Our Ref: AWE200083-L01: BCP/bcp
Contact: Dr Brett C. Phillips

22nd February 2021

RESPONSES TO FLOODING SUBMISSIONS, ASPECT INDUSTRIAL ESTATE, KEMPS CREEK, NSW

Figure 29 200 yr ARI Flood Hazards - Stage 1 Conditions

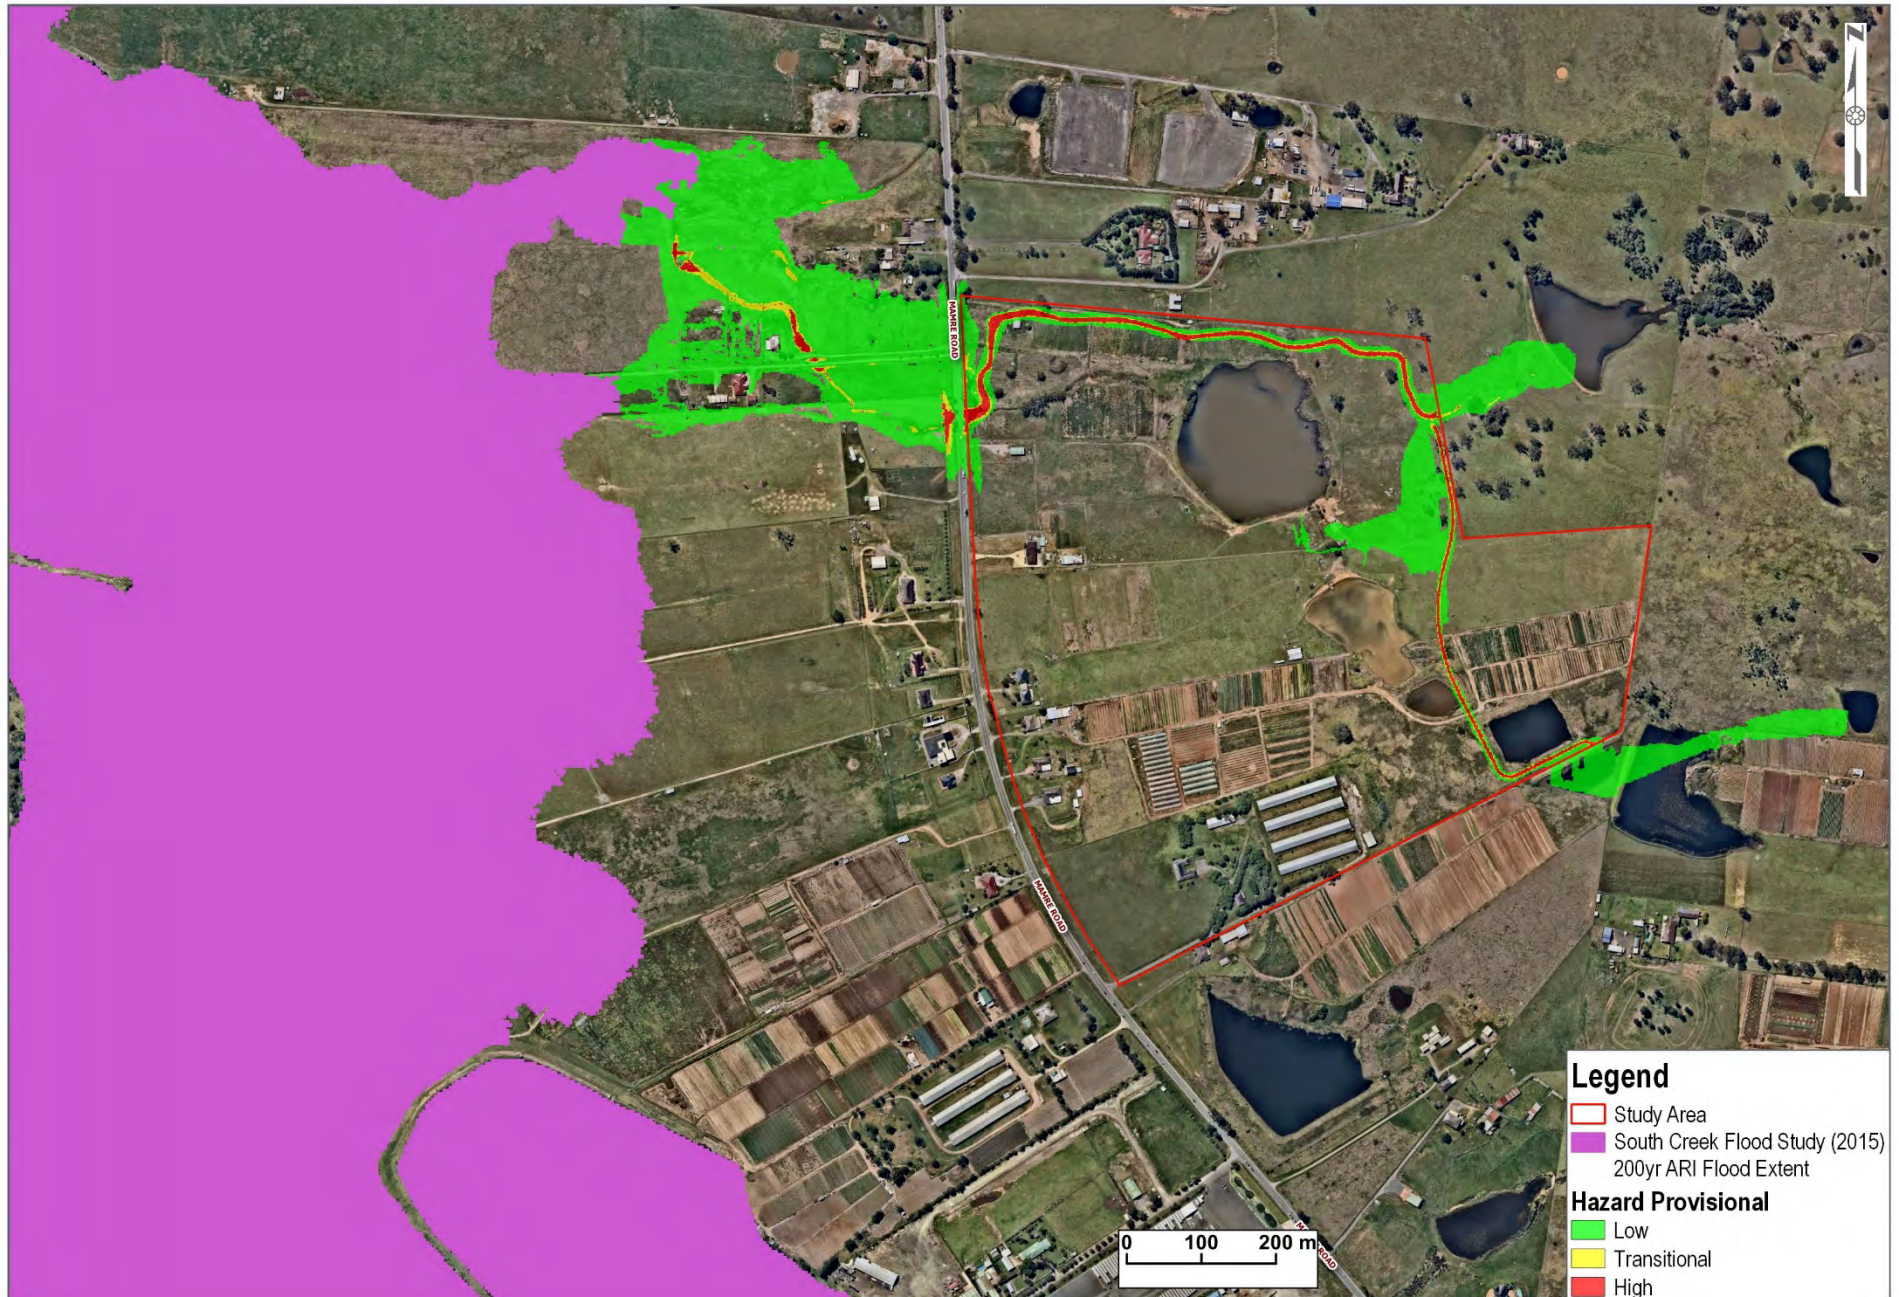
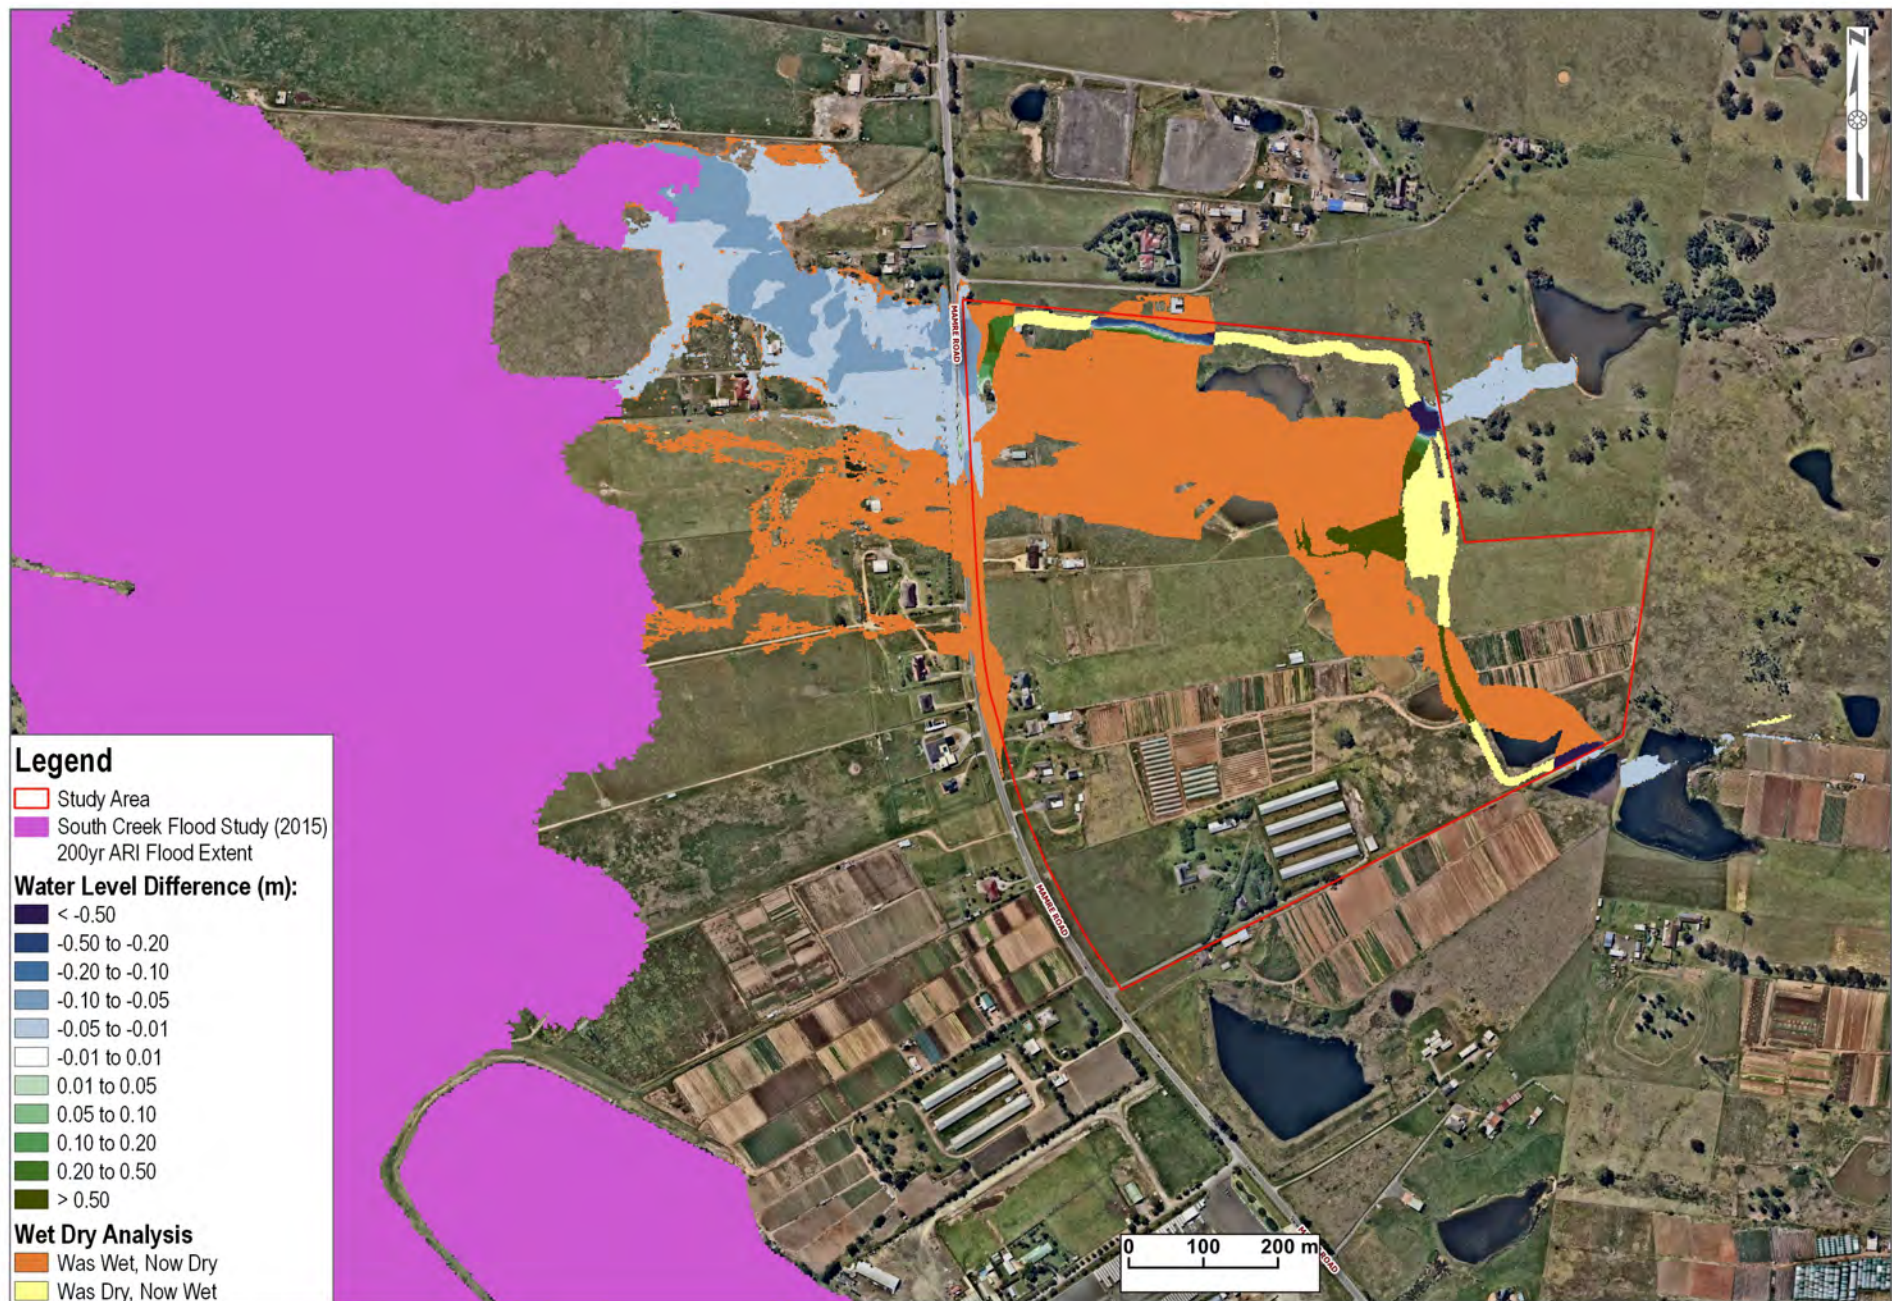
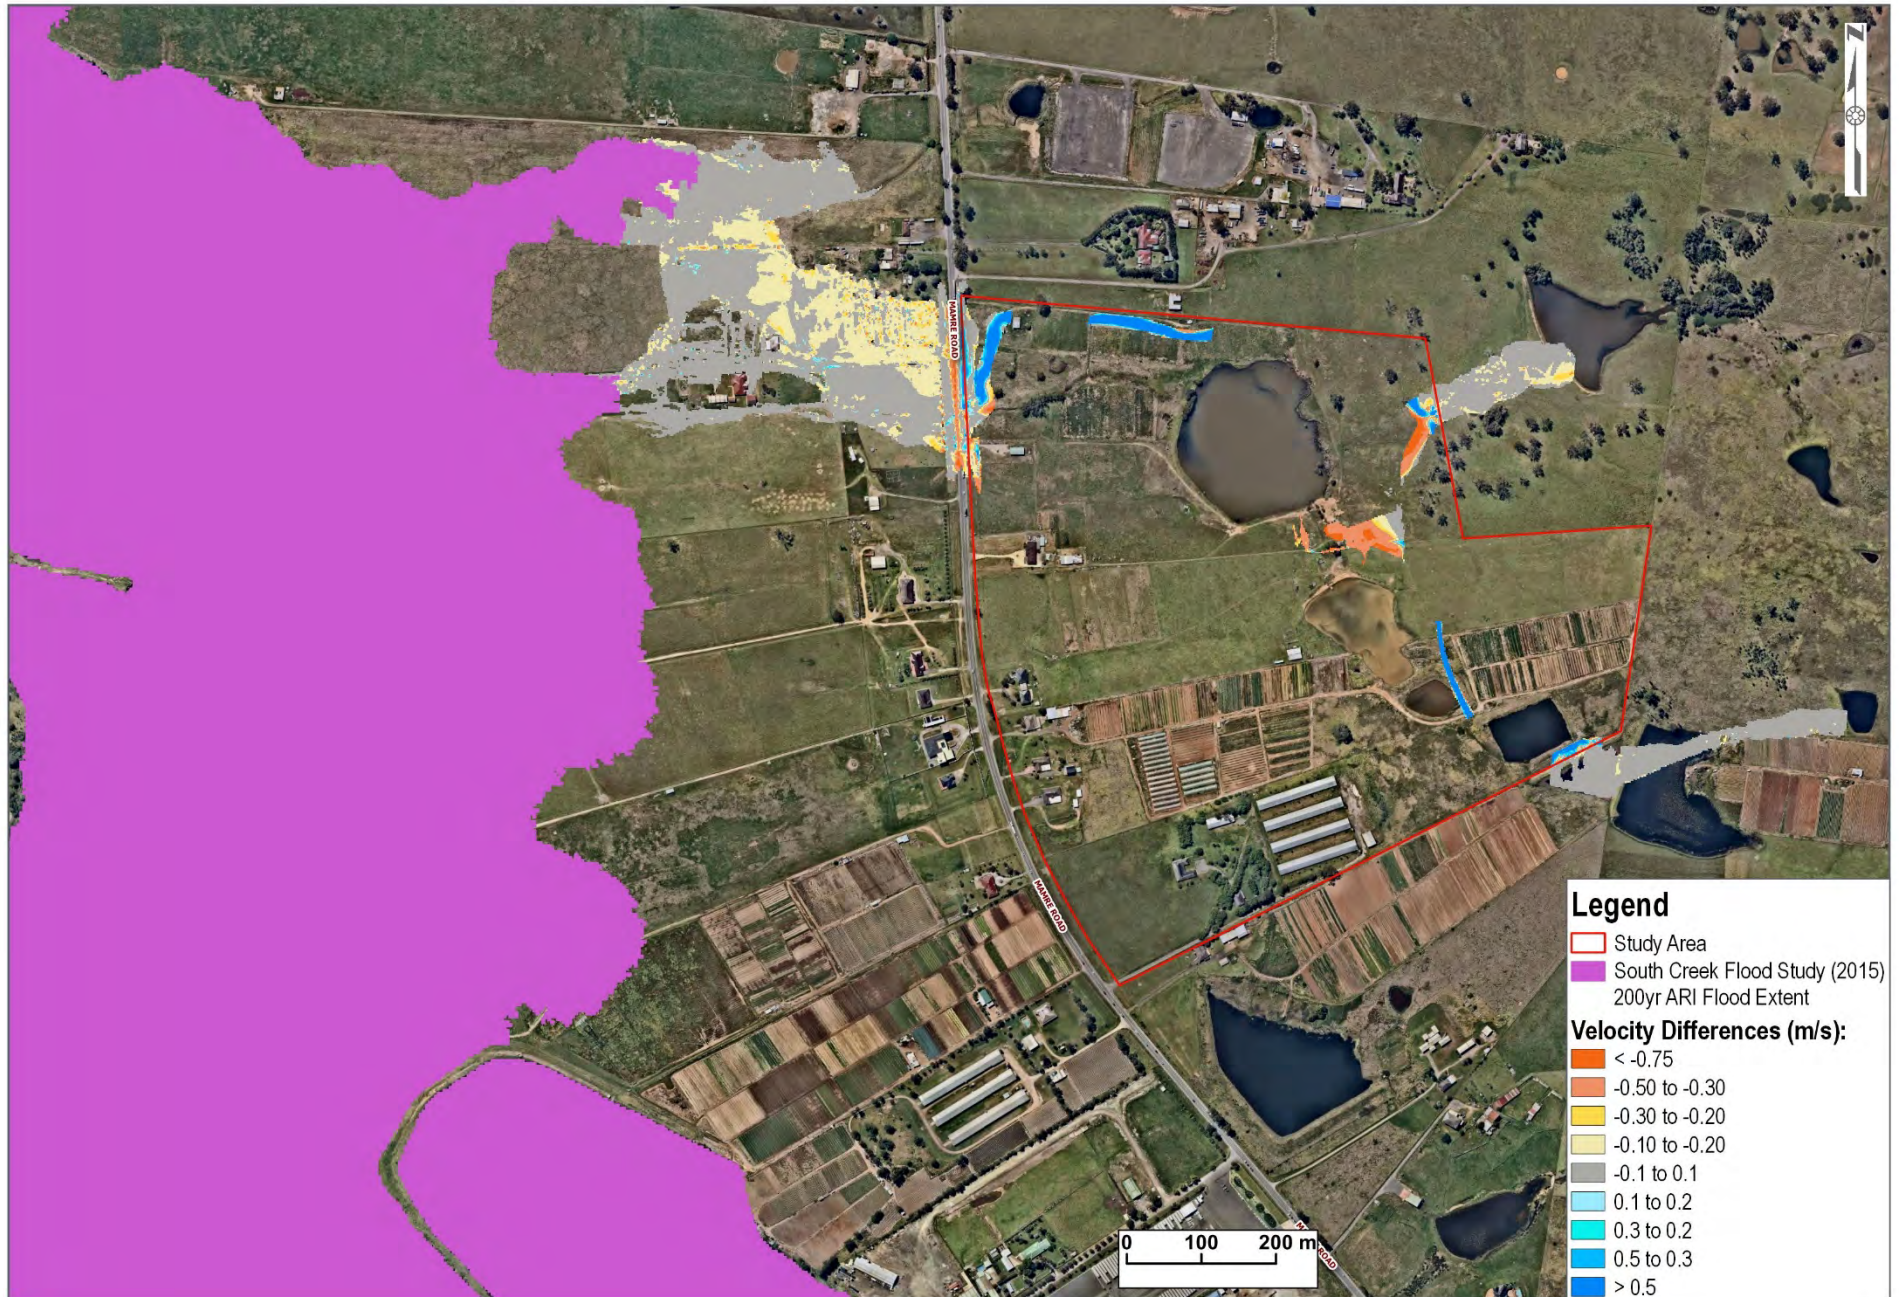
- *The developed scenario maps present local overland flow for Stage 1 which comprises of two industrial lots on the northern part of the site. However, from a flow management perspective, an overland flow study should consider the ultimate developed scenario of the site instead of considering each progressive development independently.*

- *All maps for developed conditions should properly depict the layout of the development, locations of proposed constructed channels and the location of the proposed detention basin.*

The final masterplan has been assessed and the results of the assessment have been incorporated into an updated version of the FIA report.

The updated Figures have been incorporated into an updated version of the FIA report.
